**From:** [REDACTED]  
**Sent:** 15 February 2021 19:02  
**To:** Kathryn Welch  
**Subject:** RE: Request for further information AW/354/20/T

Further to your request for more information regarding the trees at 4 The Spinney Aldwick  
The Oak tree is situated in the rear garden close to the rear southern boundary  
The overall spread of the oak tree is 7 meters  
The 3 Mable trees are situated to the side of the Garage which is attached to the house on right hand side of the property approx 2 meters from Garage  
The overall spread of the Maples is aprox 6.5 meters

1) Oak tree

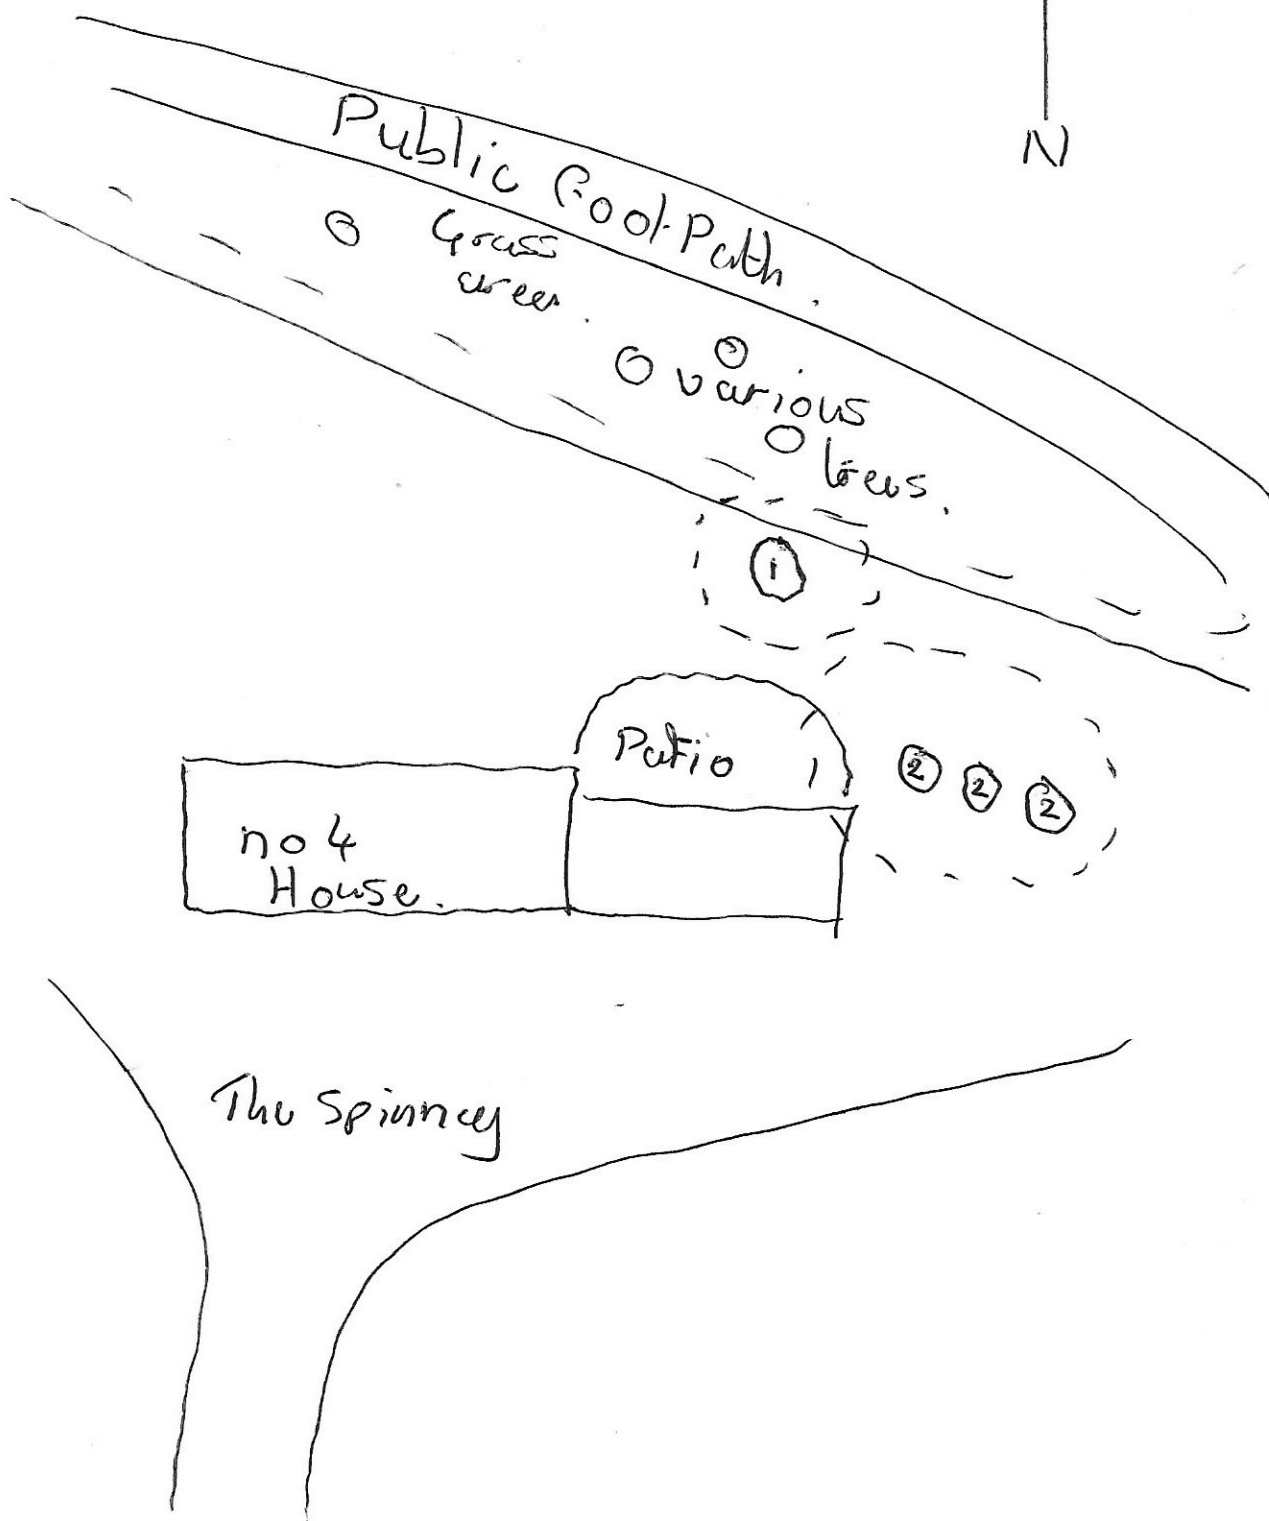
Thank you for those details. Having gone back into the application today I have noticed I'm still awaiting a clearly labelled plan. The one which has been sent in has 5 trees marked out and although the trees are numbered there is still no reference back to this in the description.

Could I just confirm one more thing, the spread measurements provided are these existing or proposed spread measurements? We require the proposed spread measurements.

The plan I sent with numbered trees on are t1 which is a English oak tree and the numbered t2 are field Maple trees  
Hope this is the details that you require

They would be the proposed spread measurements as the branches to be removed are only on one side of the tree which are overhanging patio area and also the Garage
